STATE OF NORTH CAROLINA
DEPARTMENT OF TRANSPORTATION

June 20, 2013

Subject: **Additional Information in Response to the N.C. Division of Water Quality's On-Hold Letter** for the proposed widening from SR 1003 (North Main Street) and SR 1820 (Skeet Club Road) to NC 68 in High Point, Guilford County; Division 7; TIP U-3615; Federal Aid Project No. STP-1820(2); WBS Element No. 34962.1.1

Reference: 1) Application for Section 404 Individual Permit, Section 401 Individual Water Quality Certification, and Randleman Lake Buffer Authorization, April 25, 2013.
2) NCDWQ On-Hold Letter, dated May 31, 2013, received June 17, 2013.

SITE 1

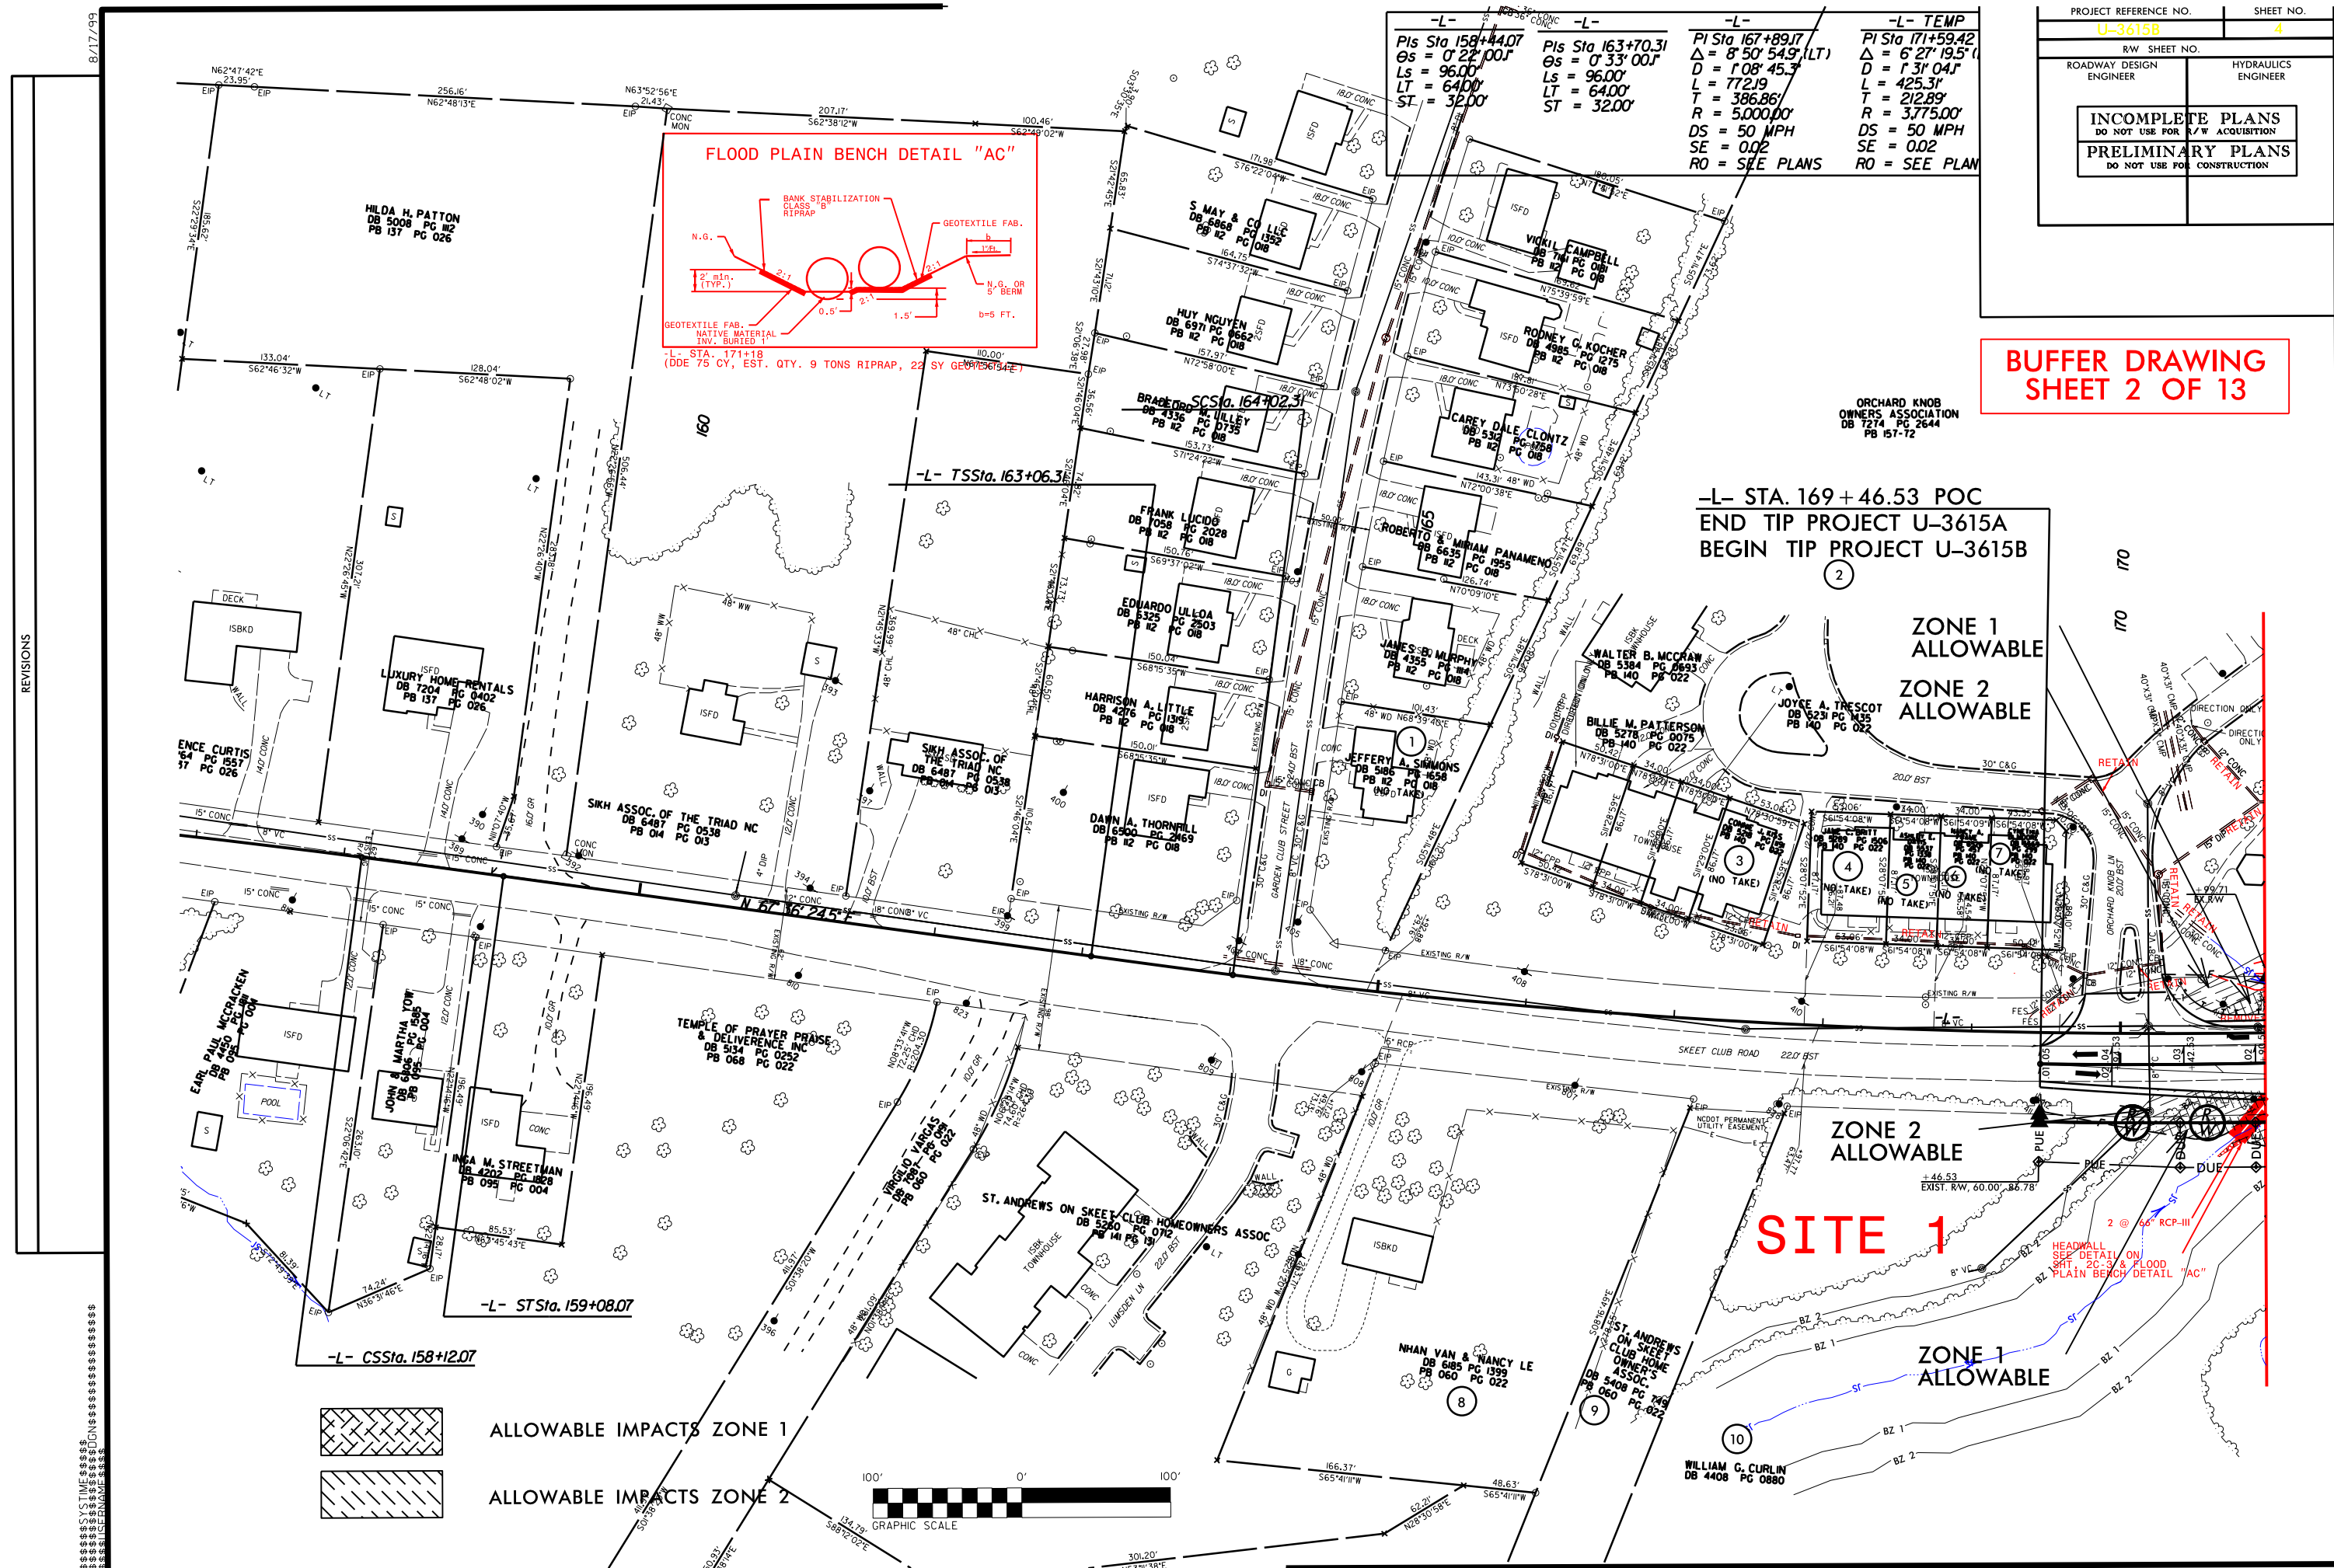
6. *At site 1, there's a pipe extension and a rip rap pad, which extends into the buffer. Is this off-site water?*

Can this be shifted out of the buffer, and can a PSH be used instead?

If the pad needs to remain in the buffer, it should be counted as an impact.

Yes.

It cannot be shifted out of the buffer because we are extending the existing 24" cross pipe. The rip rap pad is at the outlet of this pipe. As for the PSH, the water is offsite water and the 24" cross pipe conveys too much water for a PSH.

The riprap pad will be located inside buffer zone 2 only and the impact has been accounted for on the impact summary sheet.

SITE 5

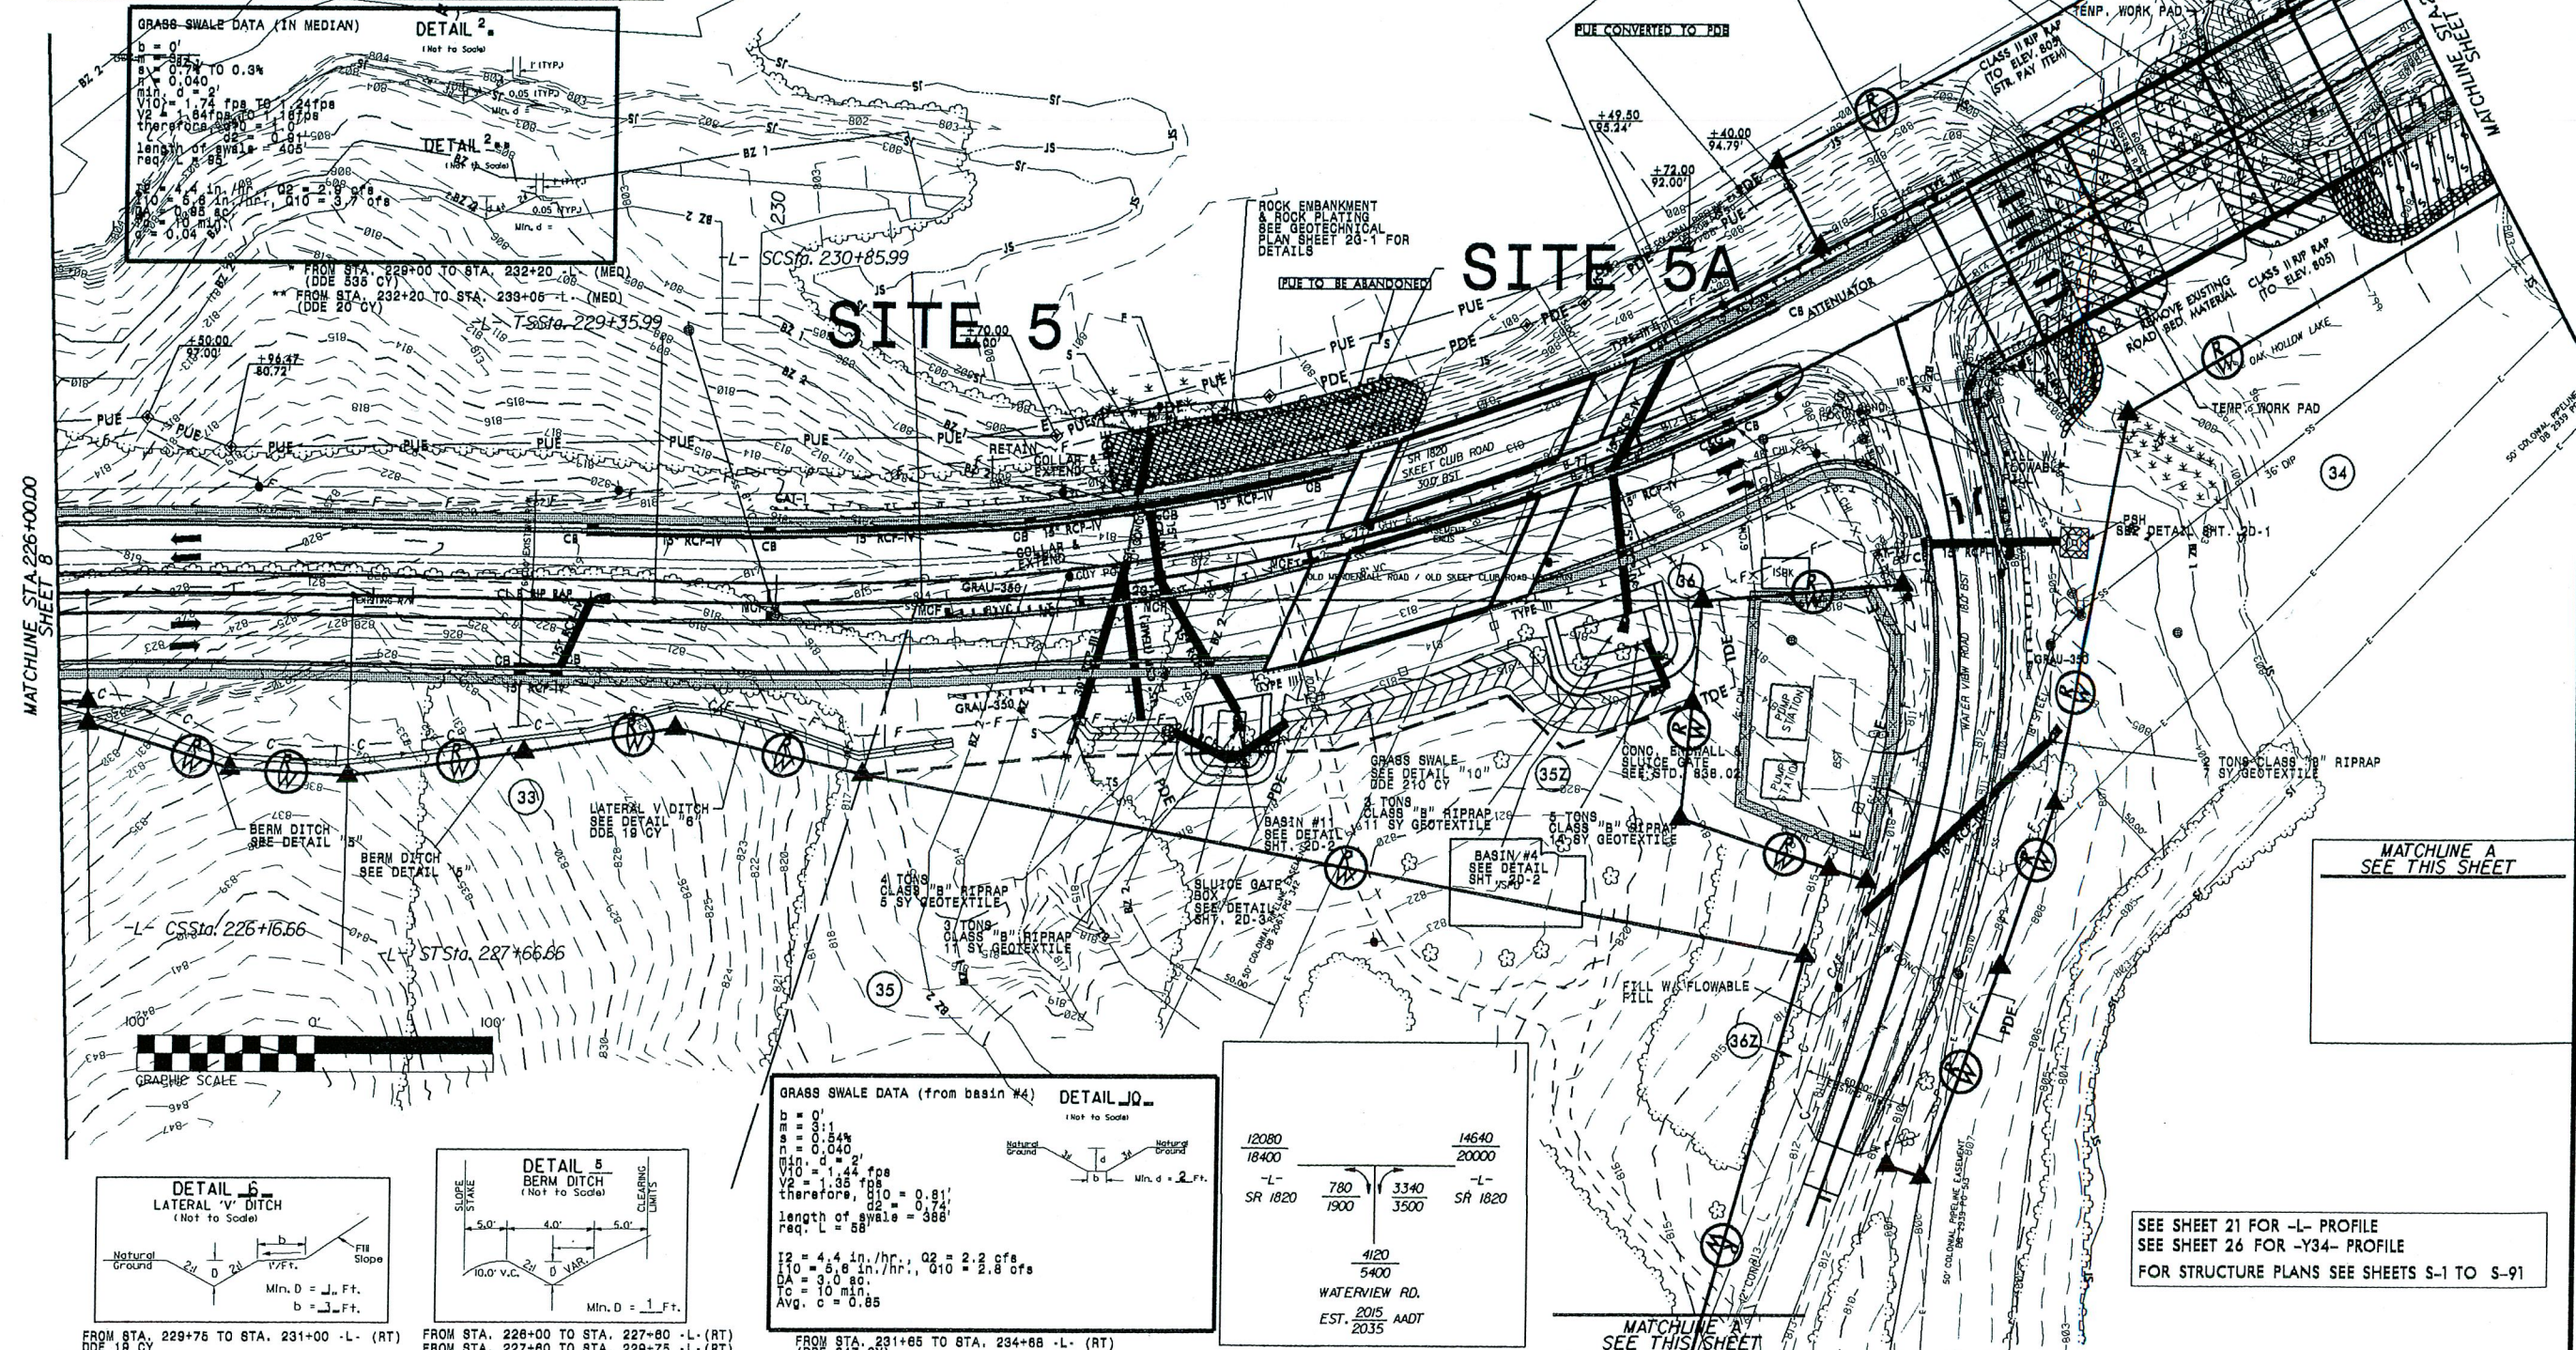
11. *At site 5, impacts for the ditch should be broken out on the southeast side.*

On the southwest side, is berm ditch carrying off-site water?

Based on a telephone conversation, May 23, 2013, between Shawn Harris (Hydraulics Unit) and Amy Euliss (DWQ), the impacts are not broken out on the southeast side because the impacts are due to the crosspipe extension and not the swale itself.

Yes, this is off-site drainage.

SITE 6

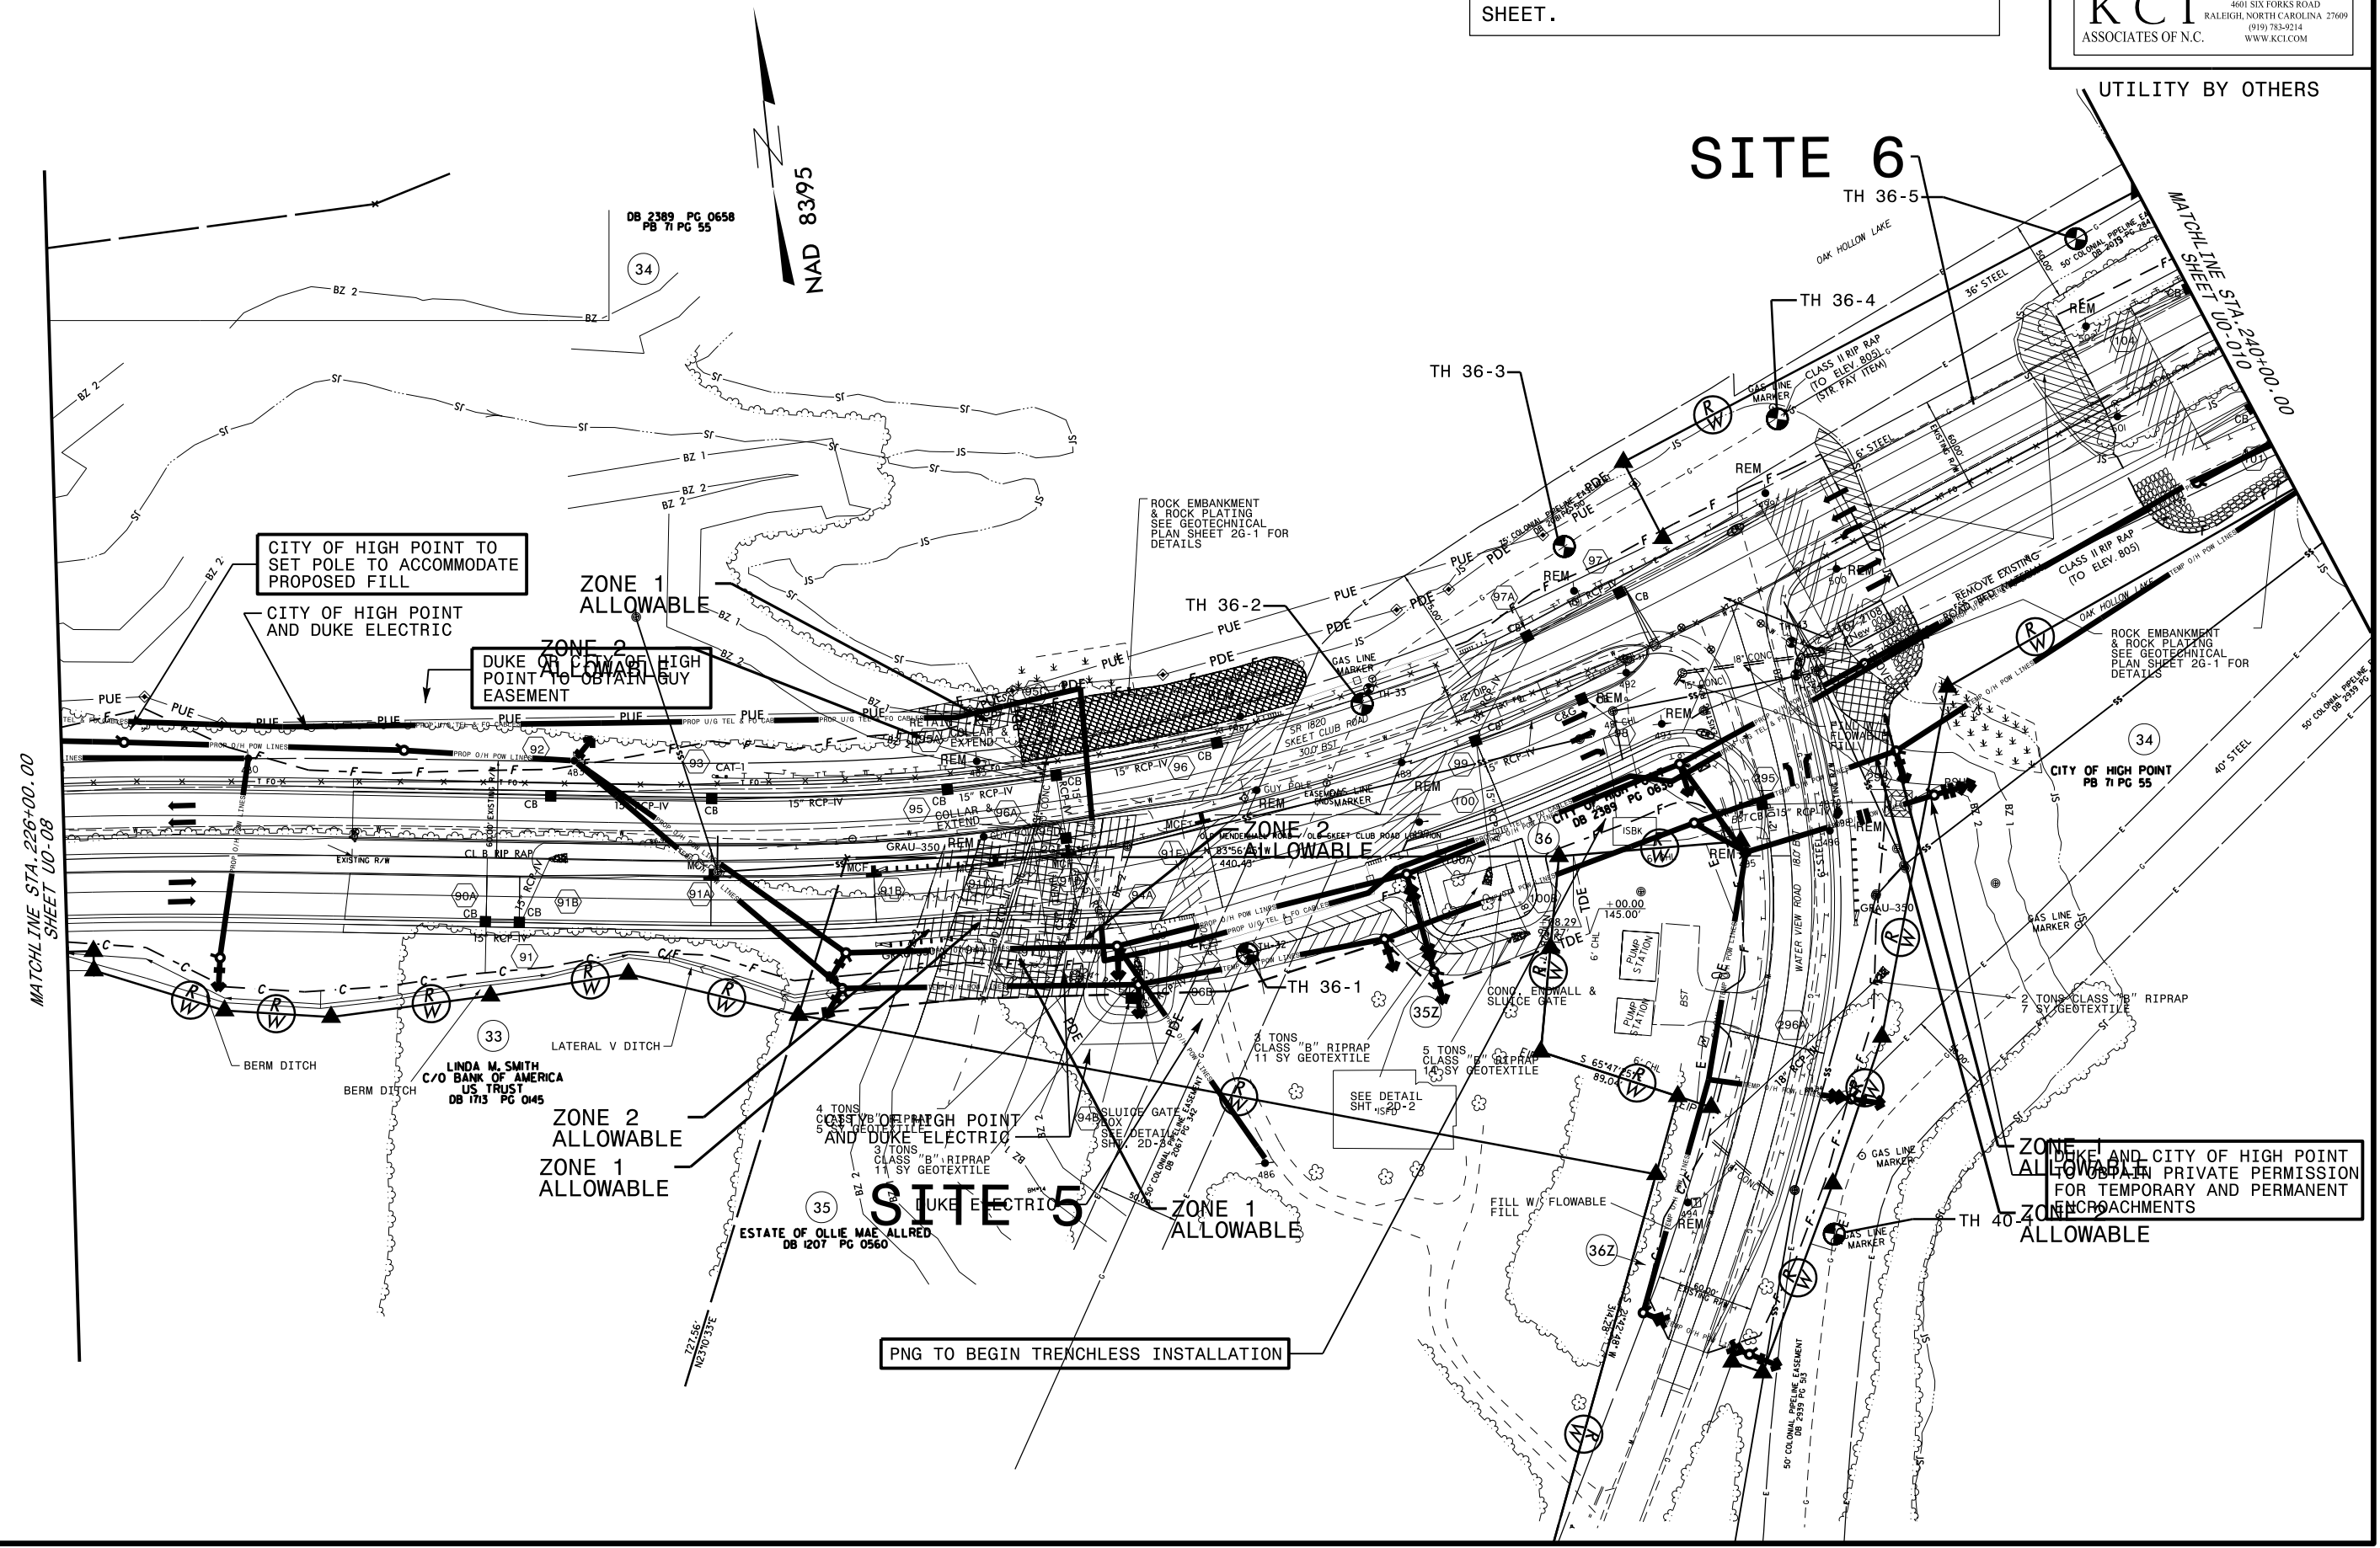
13. For site 6, you need to separate out bridge and roadway buffer impacts. Also, roadway crossing impacts are only mitigable if >150' of buffer is impacted. Please review totals and calculate if necessary.

Based on a telephone conversation, May 23, 2013, between Shawn Harris (Hydraulics Unit) and Amy Euliss (DWQ), the impacts shown at site 6 have been changed to allowable.
